Application No: A/266/21/PL
Site Address: Crete House The Beeches Dappers Lane Angmering BN16 4EN
Description of works: 2 No. 2 storey extensions, replace existing bay window with bi-fold doors on the existing dwelling and the construction of 2 No. 5 bed new dwellings. This application is in CIL Zone 2 and is CIL liable as new dwellings.

Thank you for your internet representation made on 16th February 2022 which has been recorded as an objection with the comments as follows:

SITE PLAN & VISIBILITY SPLAY
1:200

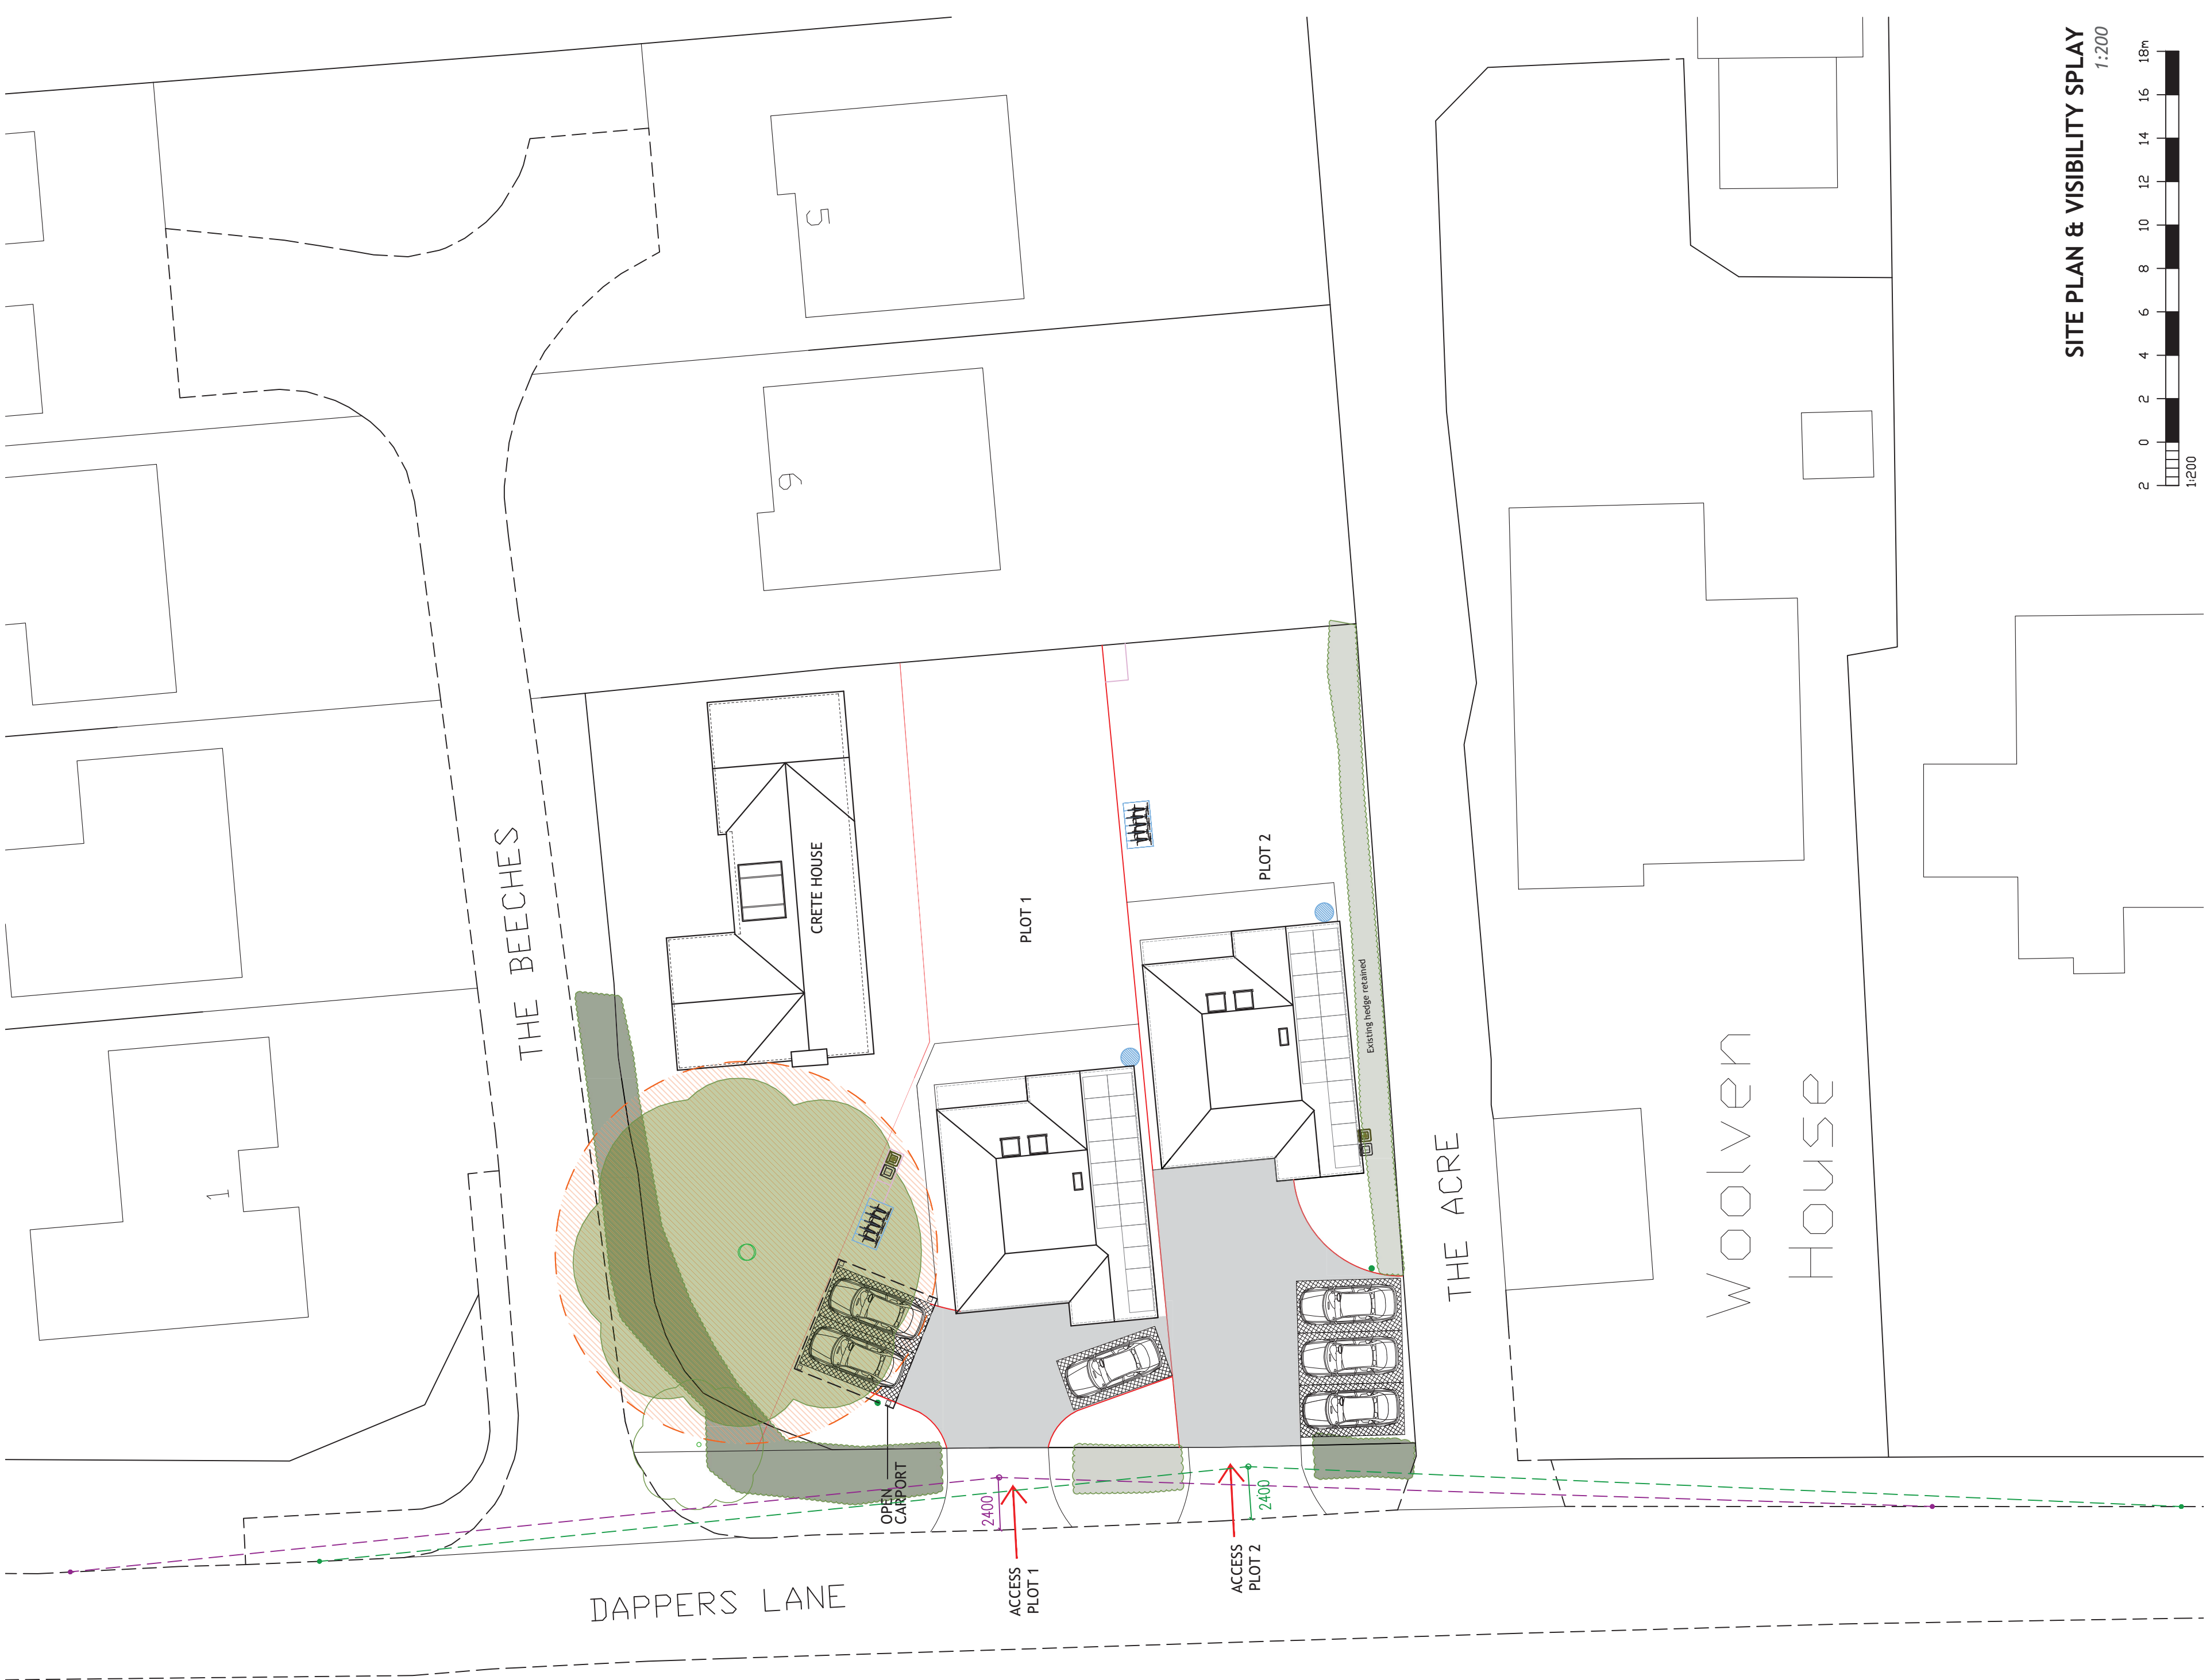
The area of land on which the existing house, to remain, is situated is not adequate for the erection of 2 additional dwellings. The resulting density would not be in keeping with the immediate surrounding area contrary to APC Policies HD5 and HD7

The proposed parking area for the 3 houses is inadequate and is likely to lead to on road parking and highway safety issues contrary to APC Policies HD8 and TM1
